TOWN AND COUNTRY PLANNING ACT 1990 FULL

Reference: H04-0600-16 **Date of Decision:** 12th September 2016
Applicant: Cook Property Holdings Ltd
Quadring Road
Donington
Spalding
Lincs
PE11 4TD
Location: Dave Cook Engineering Warehouse & Yard Quadring Road Donington
Description: Erection of 4 dwellings including access, parking and landscaping

South Holland District Council hereby give notice that this application has been REFUSED for the above proposal for the following reason(s):

Scale: 1:500/1250 @ A3	Date: 04/04/16
Drawing Title	
SCHEME SITE AND LOCATION PLAN	
Drawing No.	Revision
235-01SK01	C

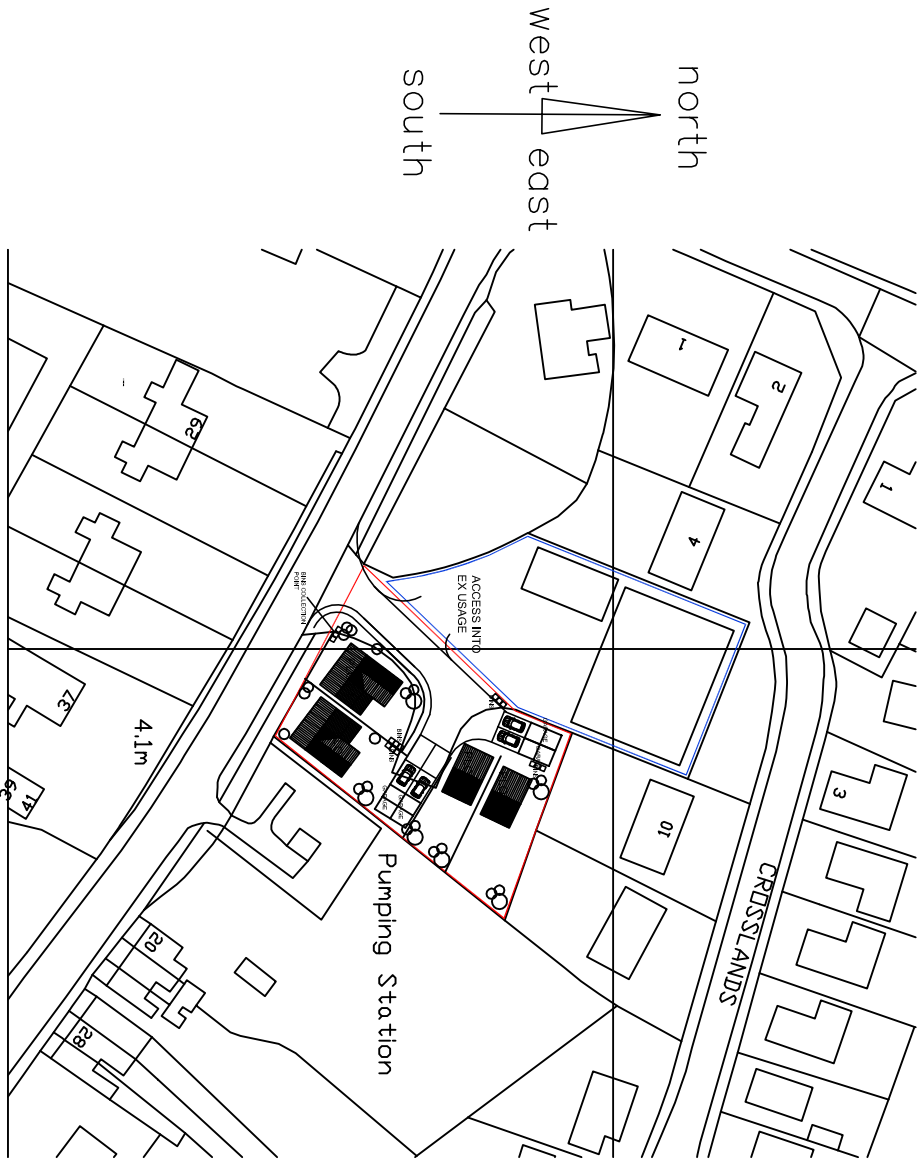
- 1 The proposed development represents a cramped form of overdevelopment out of keeping with the prevailing character of built development in the locality where existing dwellings are predominantly detached, situated on spacious plots and are generally well spaced.
The proposal is therefore contrary to Policies SG14 and SG17 of the South Holland Local Plan, 2006. These policies indicate that new development should make a positive contribution to the character and appearance of the locality and not cause unacceptable harm to residential amenity. These policies accord with national advice contained within Section 7 of the National Planning Policy Framework, 2012 which places importance on the how new development integrates into the built environment.

- 2 The layout and general nature of the development is such that future occupiers would have a reduced level of amenity as a result of shared vehicle turning and parking provision and the consequent lack of privacy and associated noise and disturbance that this would entail. This would be further eroded by the sharing of the access with the adjacent commercial building which would not be screened from the proposed

development. The future mixed use could prove detrimental to the safety of the residents of the houses due to the lack of control by the planning or highways departments on the size of vehicles using the adjacent commercial site and the fact that they would have to utilise the turning facility for turning HGV's which forms part of the application site.
